CITY OF ALBUQUERQUE

RE: Townhomes for Greg Lobbereg
Grading and Drainage Plan
Engineer's Stamp Date 12-30-2016 (File: H22D026)

Based upon the information provided in your submittal received 12-30-2016, the above referenced Grading and Drainage Plan cannot be approved for building permit and SO-19 permit until the following comments are addressed:

DRAWING TITLE:
GRADING & DRAINAGE PLAN

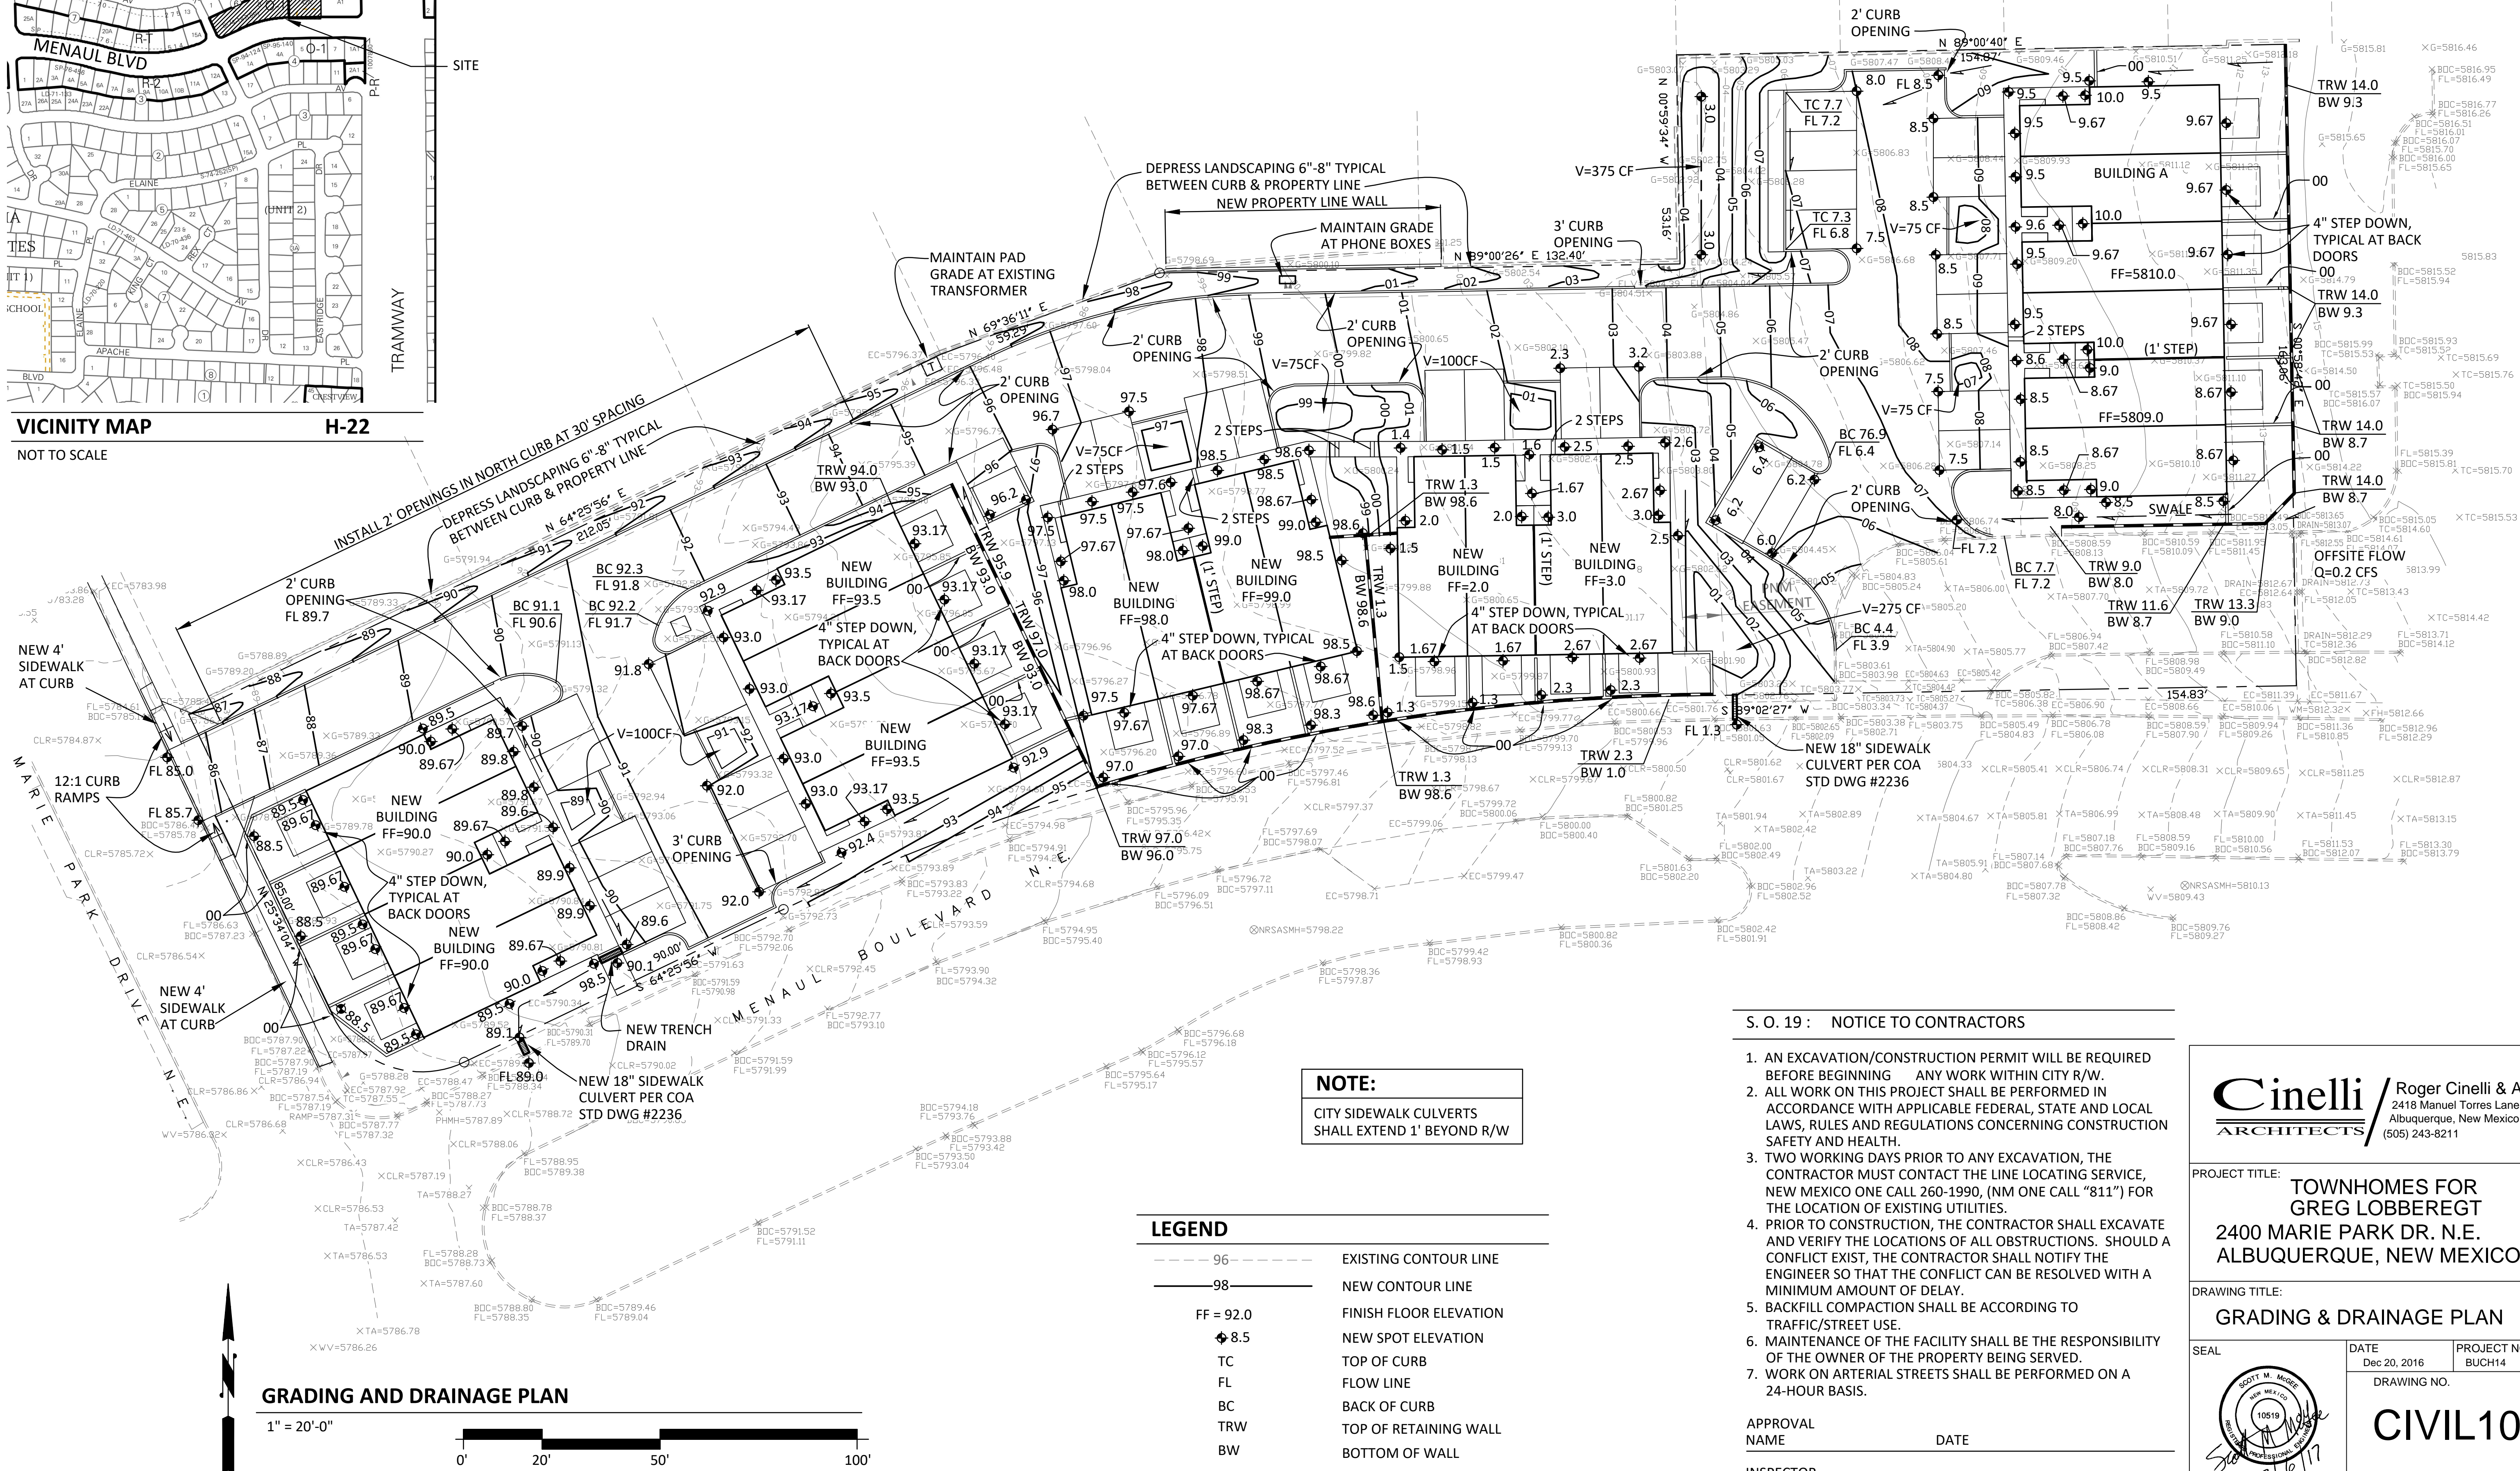
1. Provide a vicinity map.
2. Provide a narrative for offsite flow.
3. Provide back yard details and typical lot layout.
4. Provide first flush calculations for back yard separately from rest of site.
First flush volume for back yard can only be for previous surface in back yard.
5. Provide a curb cut north of the dumpster enclosure for the south east pond.
6. Provide a curb opening at regular intervals along the north side of the site.
7. Depress all landscaping area at the north side of the site.
8. ESC plan and ESC permit is required. (coordinate with a stormwater quality engineer).
9. For town house that backup to the street consider drain them to the street.
10. Extended sidewalk culvert plate 1 foot behind the sidewalk.
